Haweswater Aqueduct Resilience Programme, Marl Hill Section

**Ecology Comments on Planning Application 3/2021/0661
(Ribble Valley Borough Council)**

**John Jones
Senior Ecologist
Design & Construction Service
Lancashire County Council**

28th September 2021

FIGURE 7.7

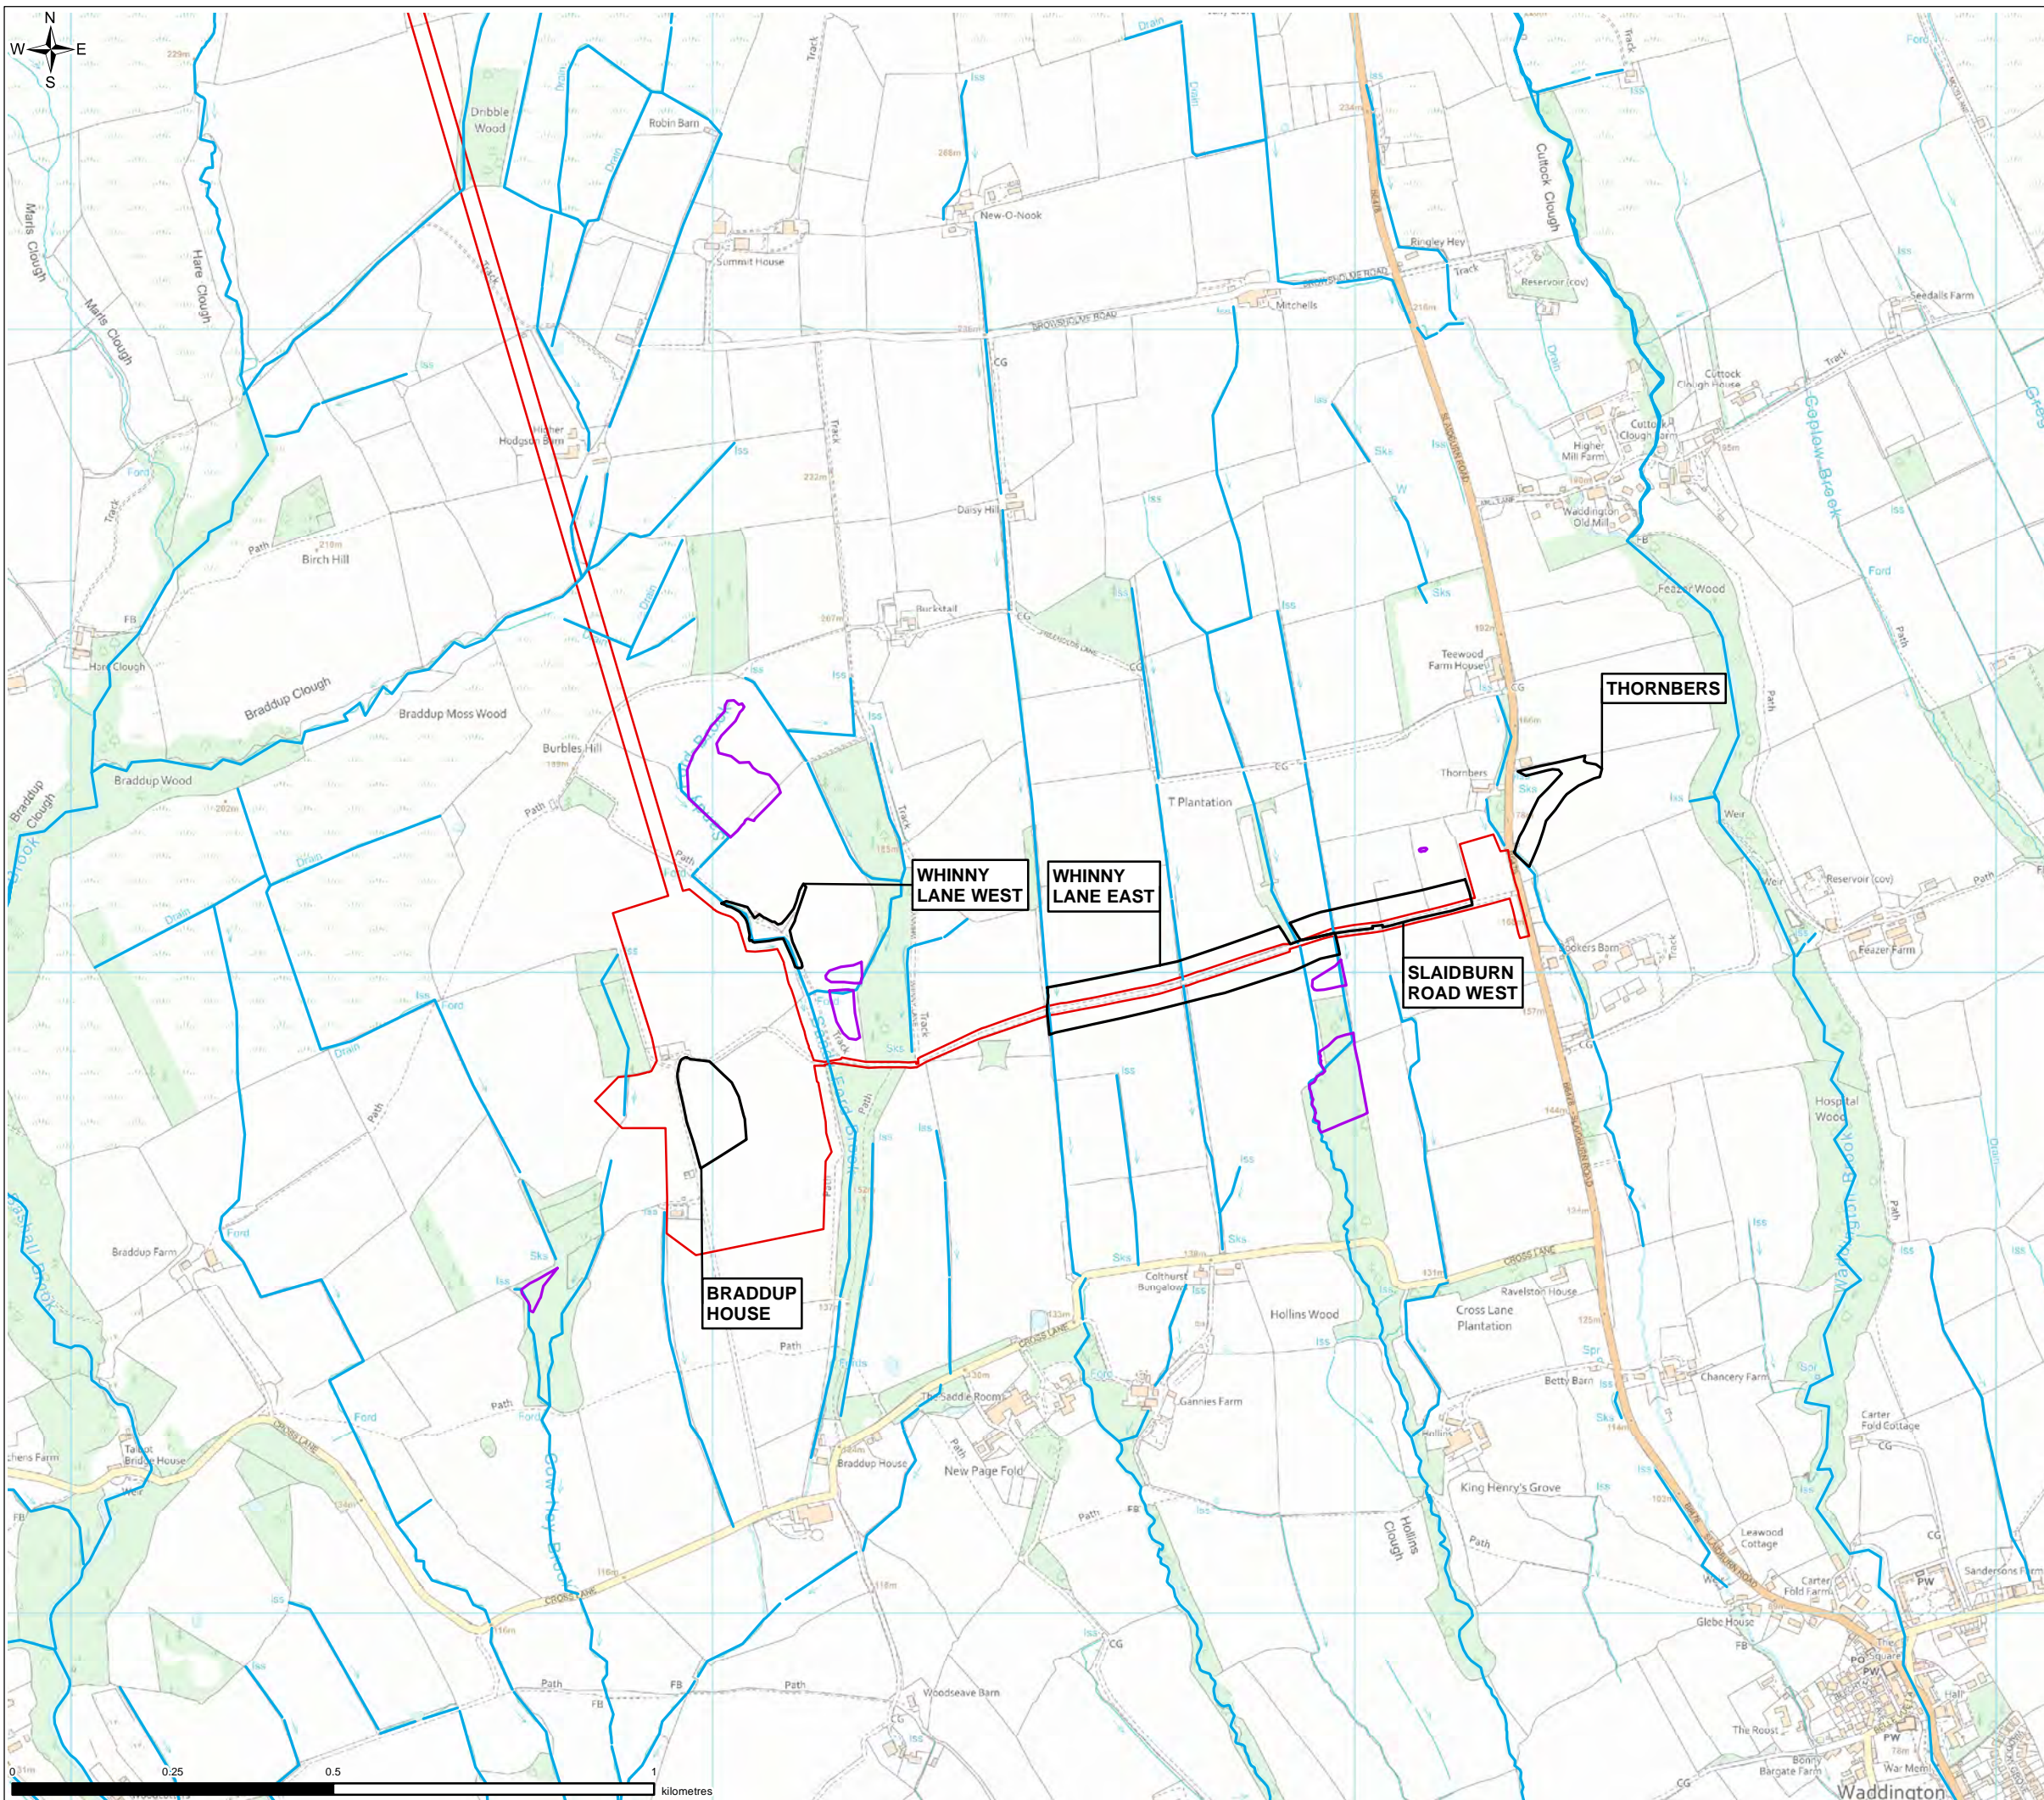
- Insufficient information to demonstrate that impacts on veteran trees are unavoidable and that a suitable compensation strategy exists.
- The assessment of impacts on groundwater dependent terrestrial ecosystems does not appear to be complete.
